This letter is in support of the Variation of Condition application to vary Condition 2 of consent 3/21/1839/Ful. Condition 2 relates to the approved plans.

We therefore request the following variations to Condition 2 of Consent 3/21/1839/FULL:

- Change drawing P1004E to drawing P1004G
- Change drawing P1005 to drawing P1005B

project no: 20042 drawing no: P1005 revision

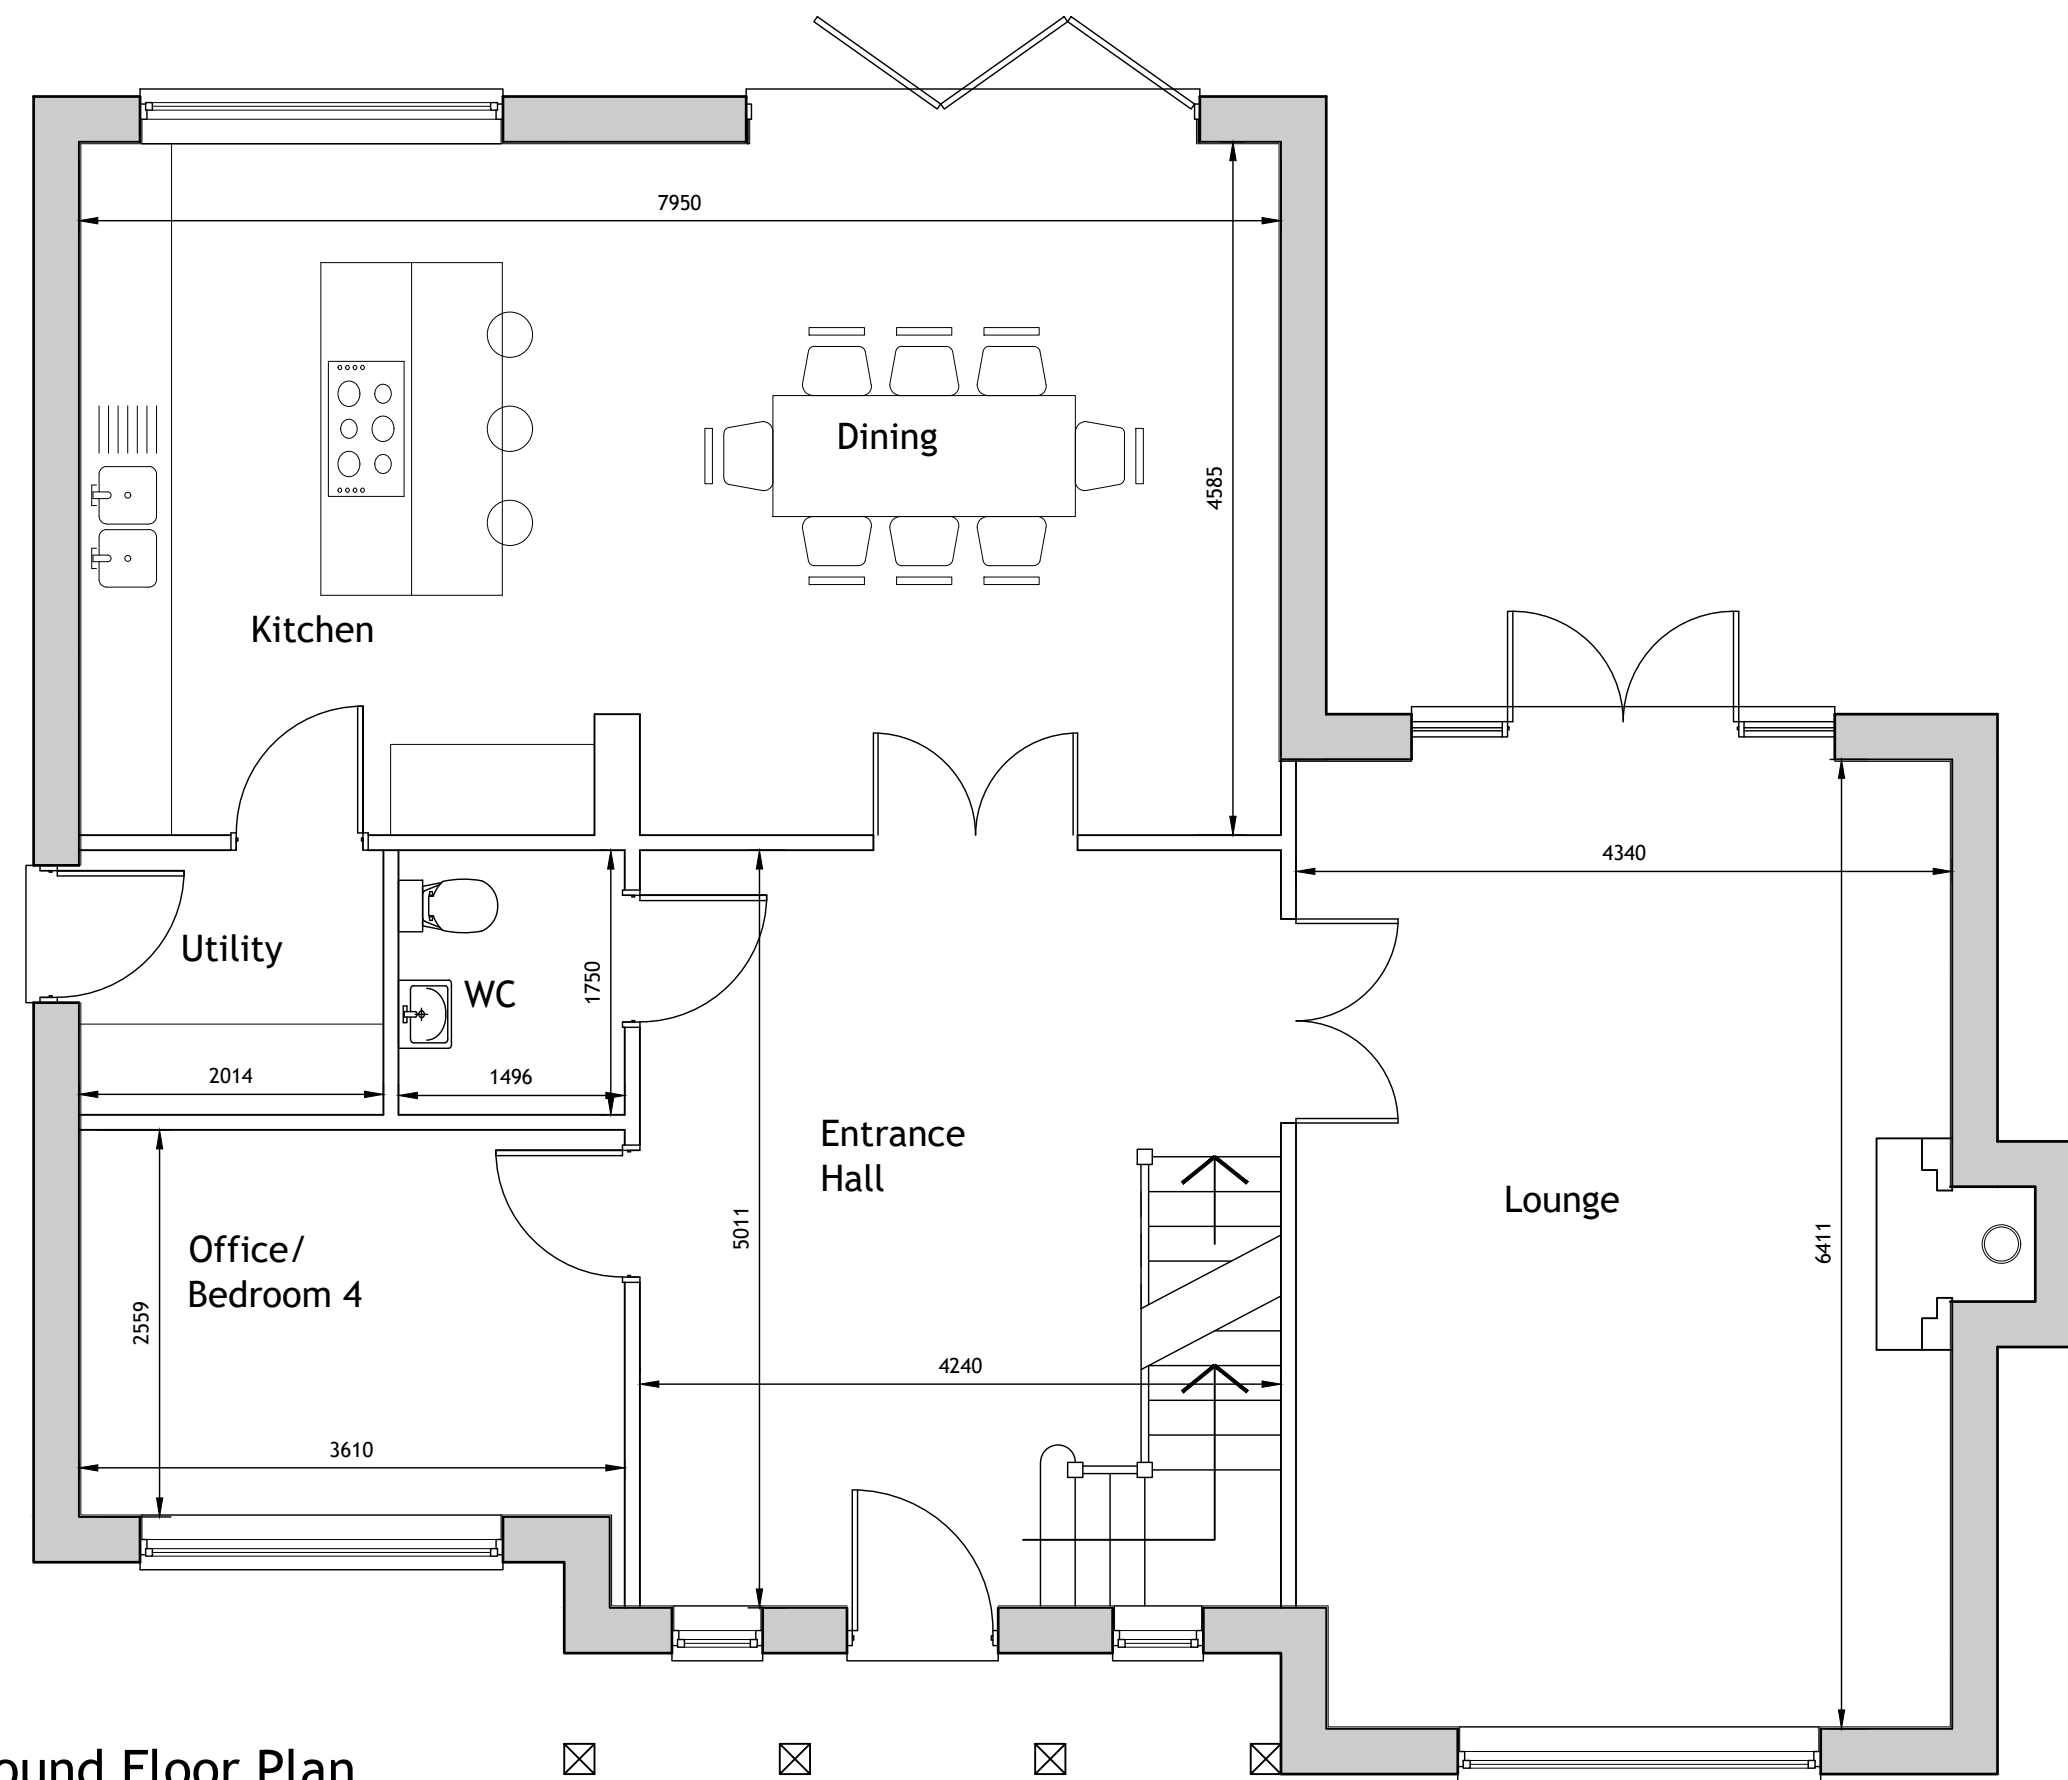
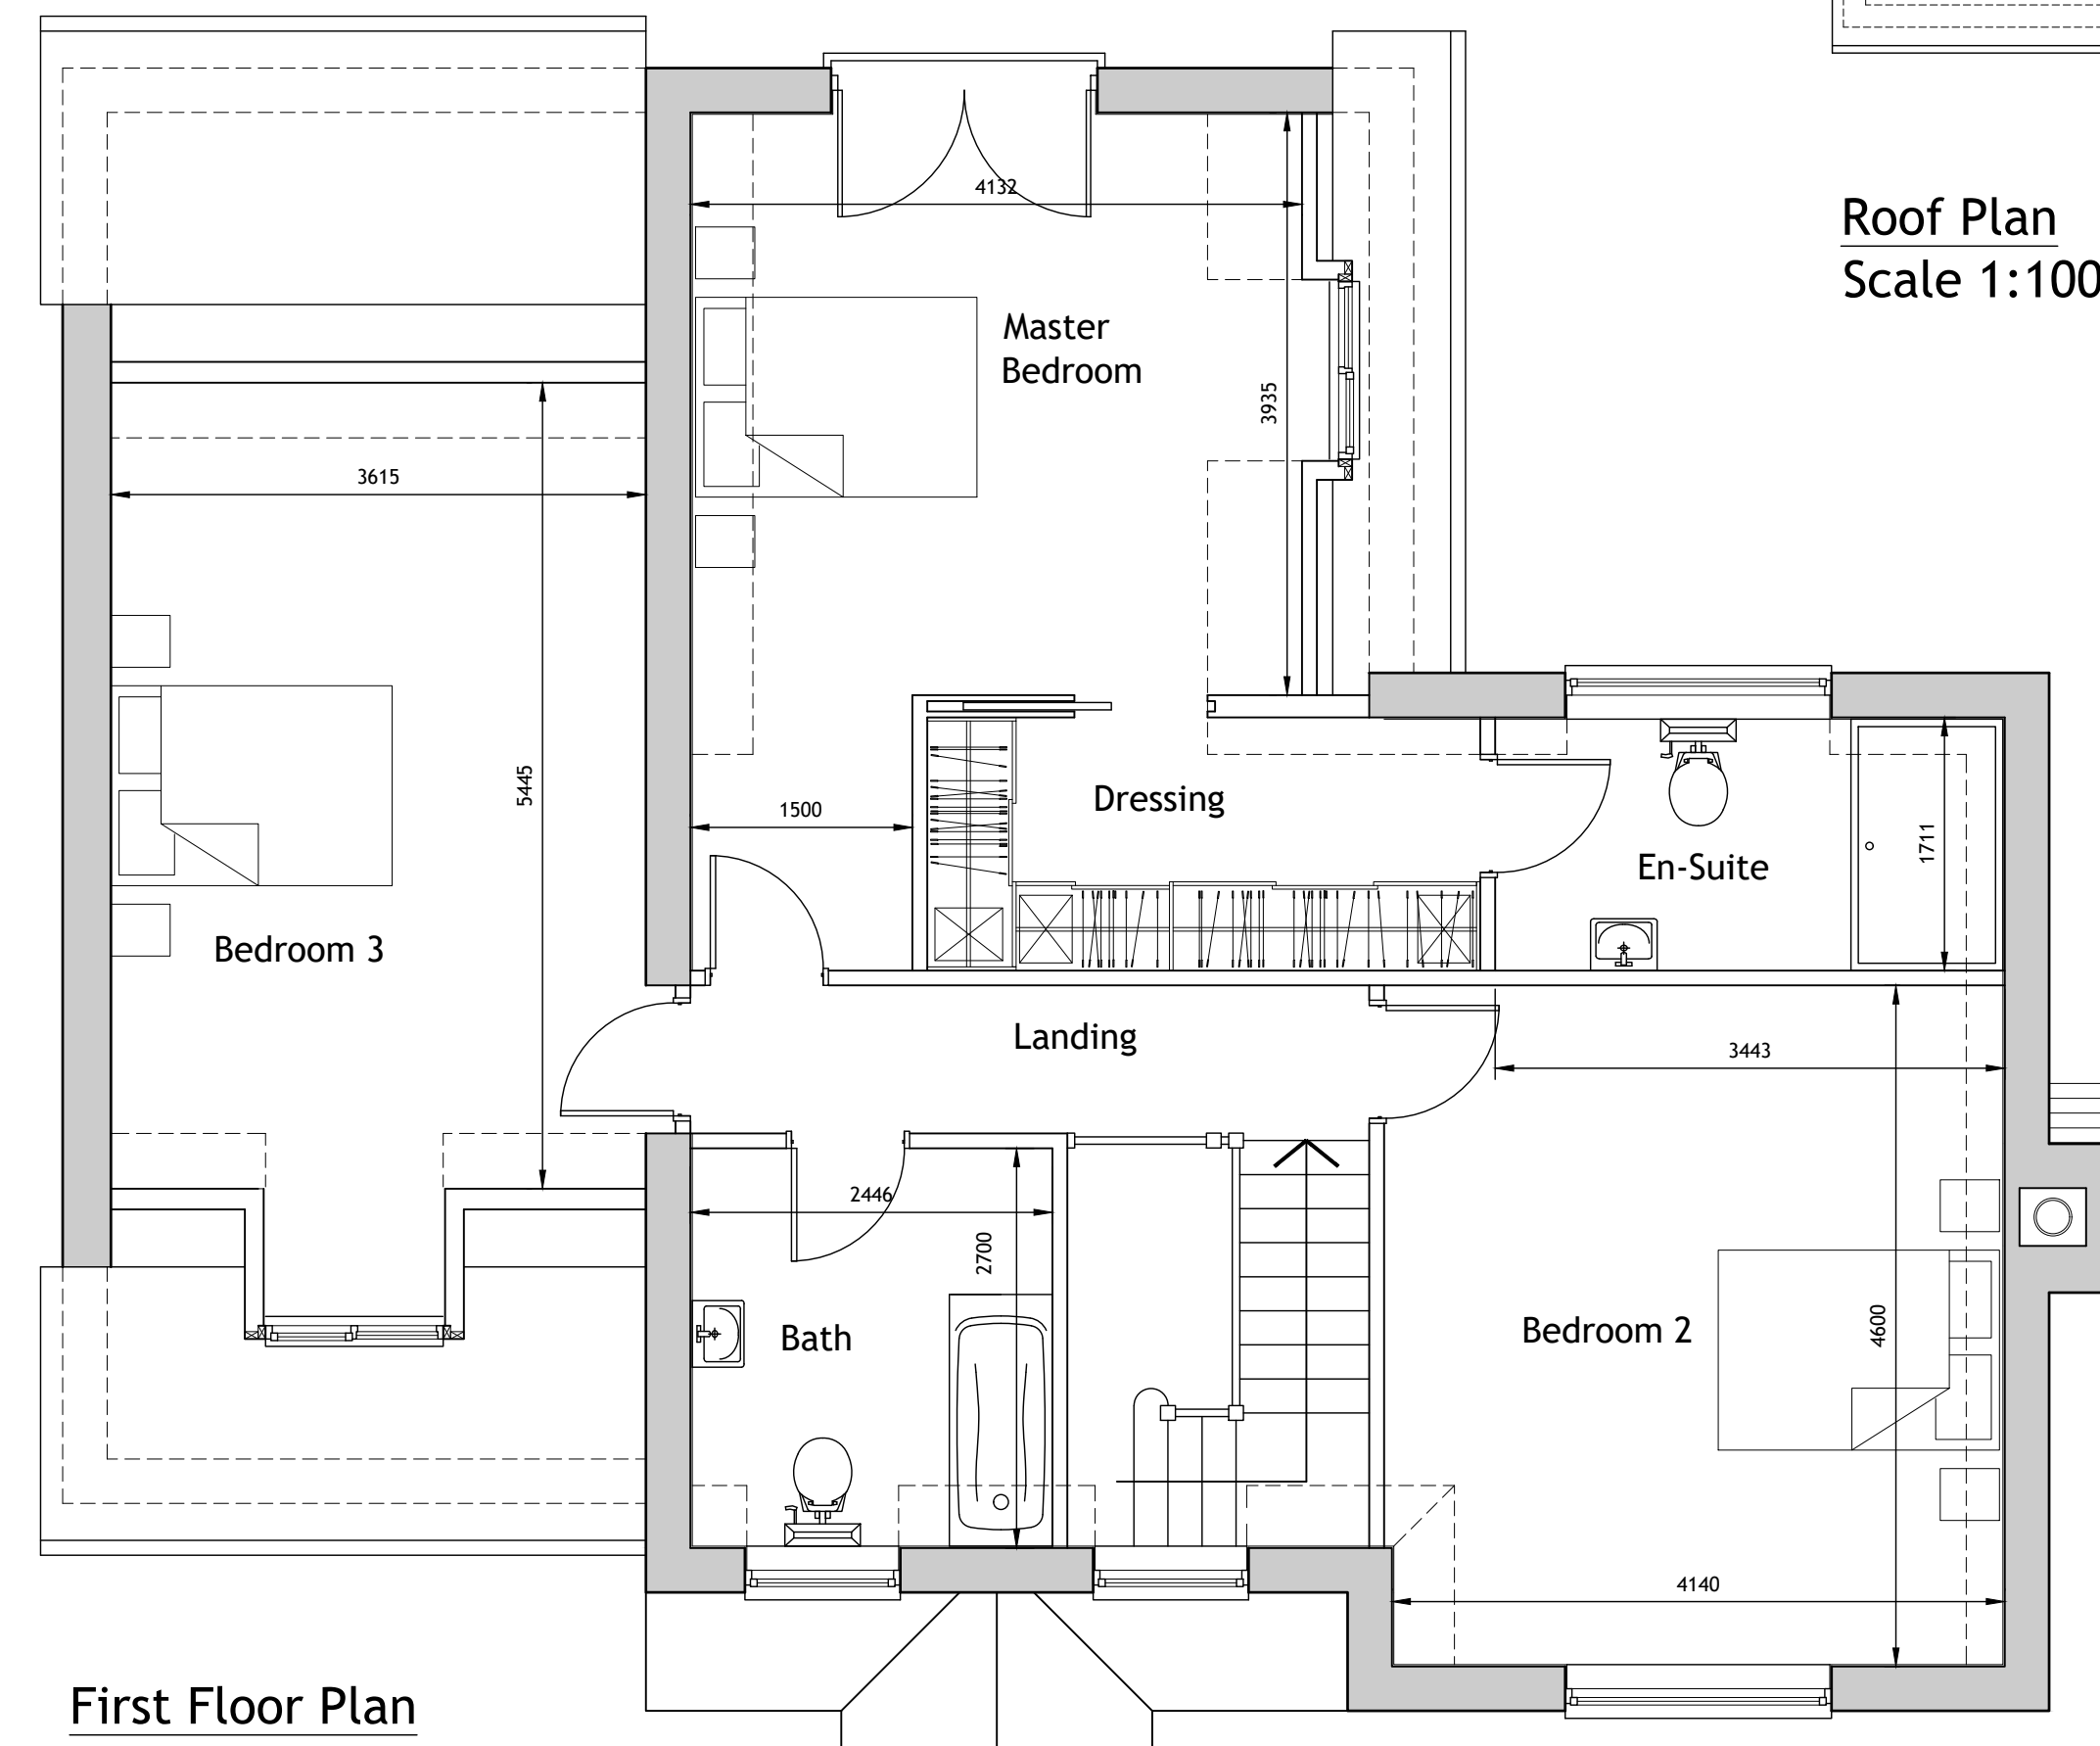
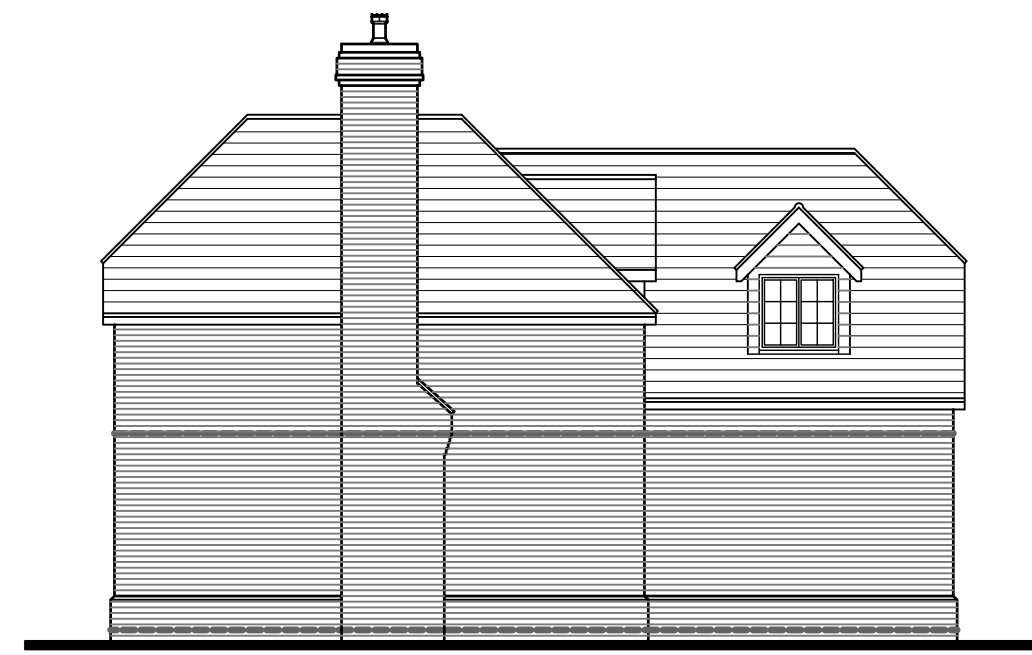
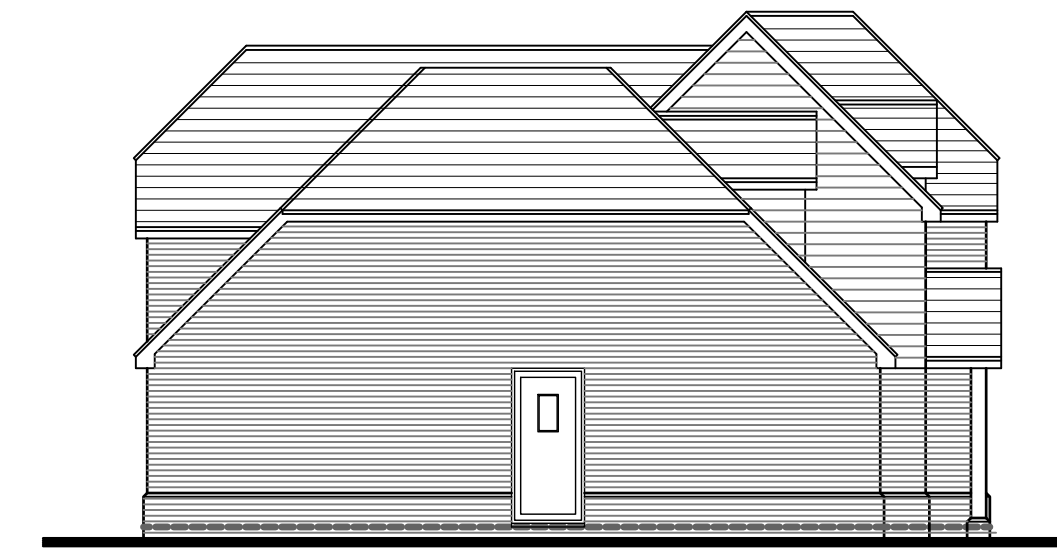
- External lounge wall moved South by 1m
- External kitchen/dining room wall moved South by 0.5m
- External kitchen/dining room wall moved West by 0.5m
- Two number windows added on West elevation at ground floor.
- Bifold door added on West elevation at ground floor.
- High level window added at first floor on East Elevation.
- Eaves and ridge raised above master bedroom on South elevation.
- Canopy added above ground floor door on East Elevation.
- Dentil brick course added above ground floor windows on all elevations.
- Chimney design revised on ground floor West elevation.
